**Your Ref:** OWPC14636  
**Our Ref:** BR/194/17/PL 30-06-2017  
**Please ask for:**  
Richard Temple

Demolition of the existing Foreshore office & decommissioning of existing underground toilets. New purpose built unisex toilet block including urinals, baby changing facilities & accessible WC, plus a separate beach office with public information point & first aid facilities. All located on the existing seafront promenade.

Promenade Opposite Clarence Road The Esplanade Bognor Regis

Proposed Elevation North
1 : 50

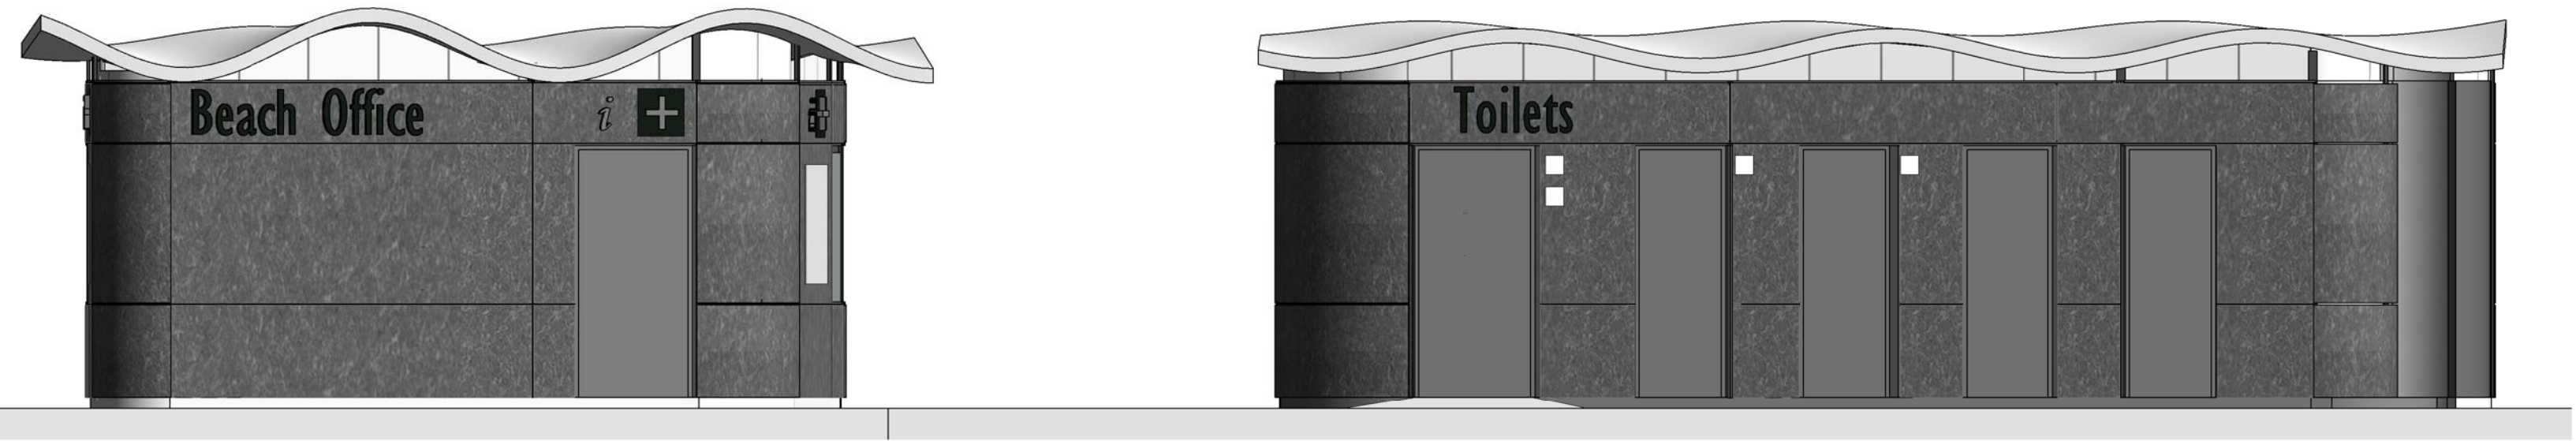
*My objections to this planning proposal are based on the location and the positioning of the toilet doors.*

*To place a toilet block in full view of a residential area shows how little consideration ADC have for their residents. I fully appreciate that a seafront property doesn't give the right to a sea view, but surely nobody with any common sense would put toilets with north facing doors directly opposite a block of residential properties. The users will be in full view as they enter and emerge, both repugnant and unacceptable.*
